Our Ref: SYD14/01465/02 (A9264199)  
Department Ref: SSD 6847

**SUTHERLAND HOSPITAL REDEVELOPMENT  
THE KINGSWAY, CARINGBAH**

Reference is made to the Department's email dated 8 May 2015, regarding the abovementioned Application which was referred to Roads and Maritime Services (Roads and Maritime) for comment in accordance with Schedule 3 of the *State Environmental Planning Policy (Infrastructure) 2007*.

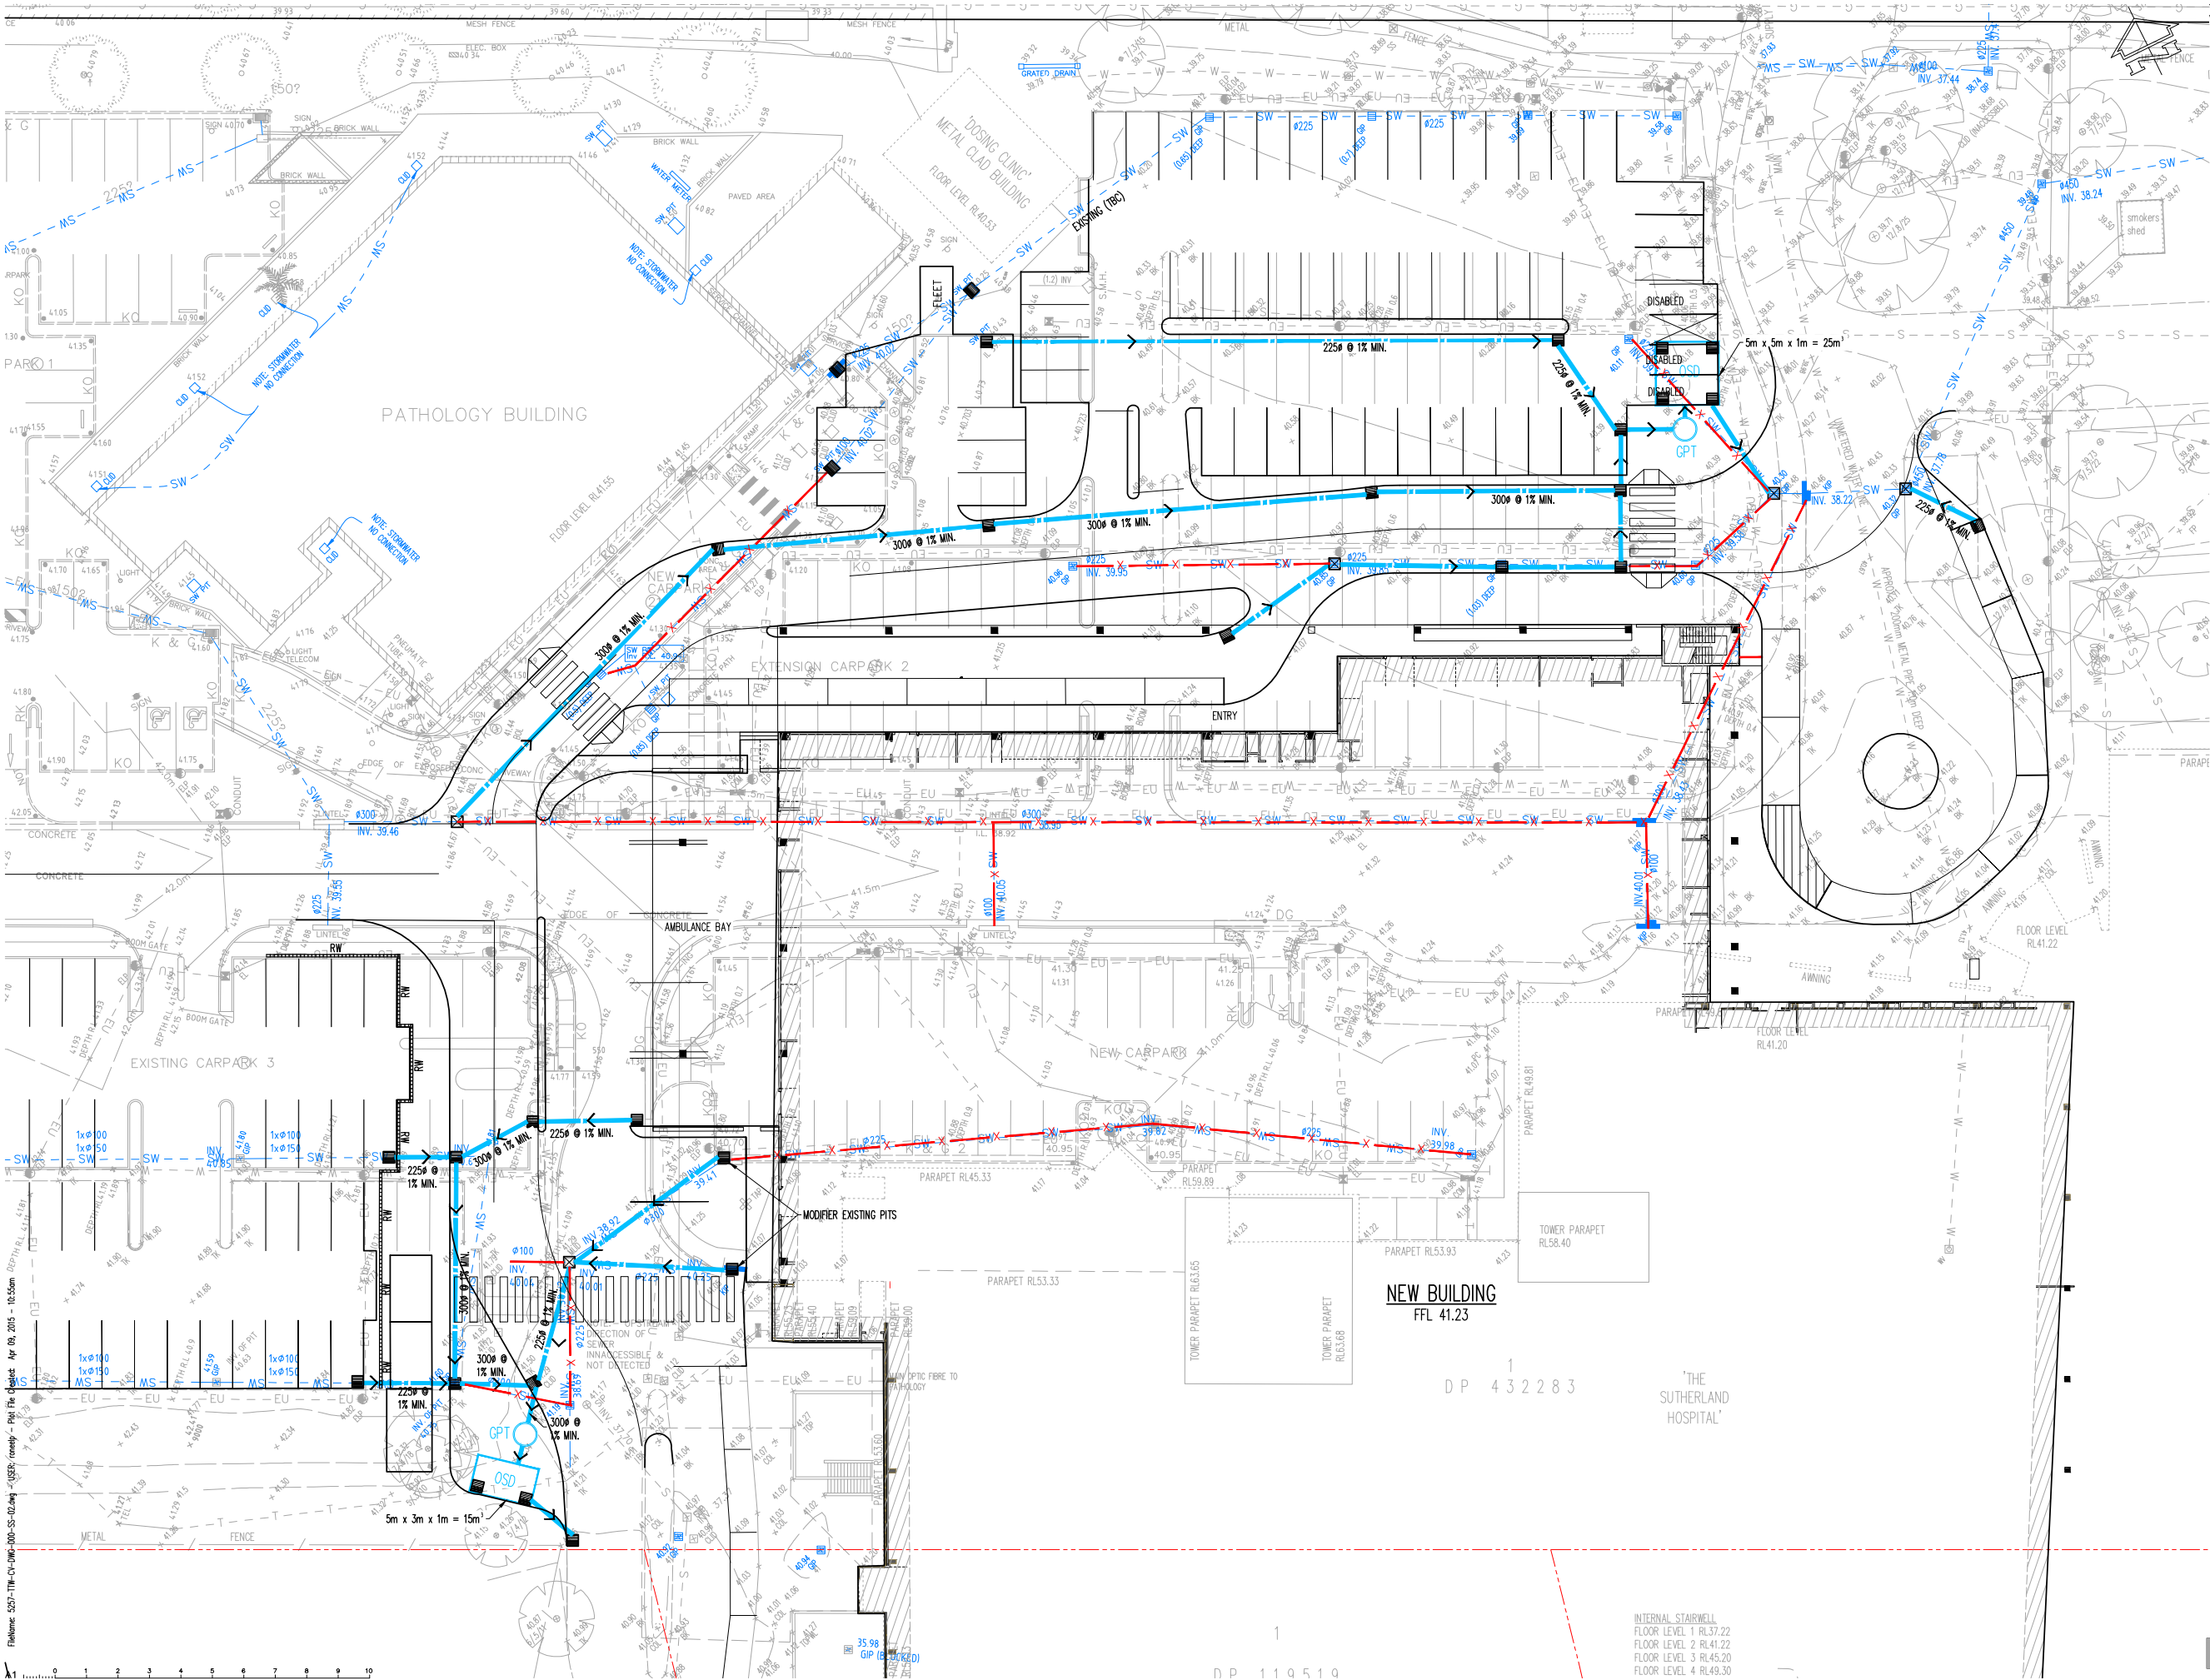
2. Detailed design plans and hydraulic calculations of any changes to the stormwater drainage system are to be submitted to Roads and Maritime for approval, prior to the commencement of any works.
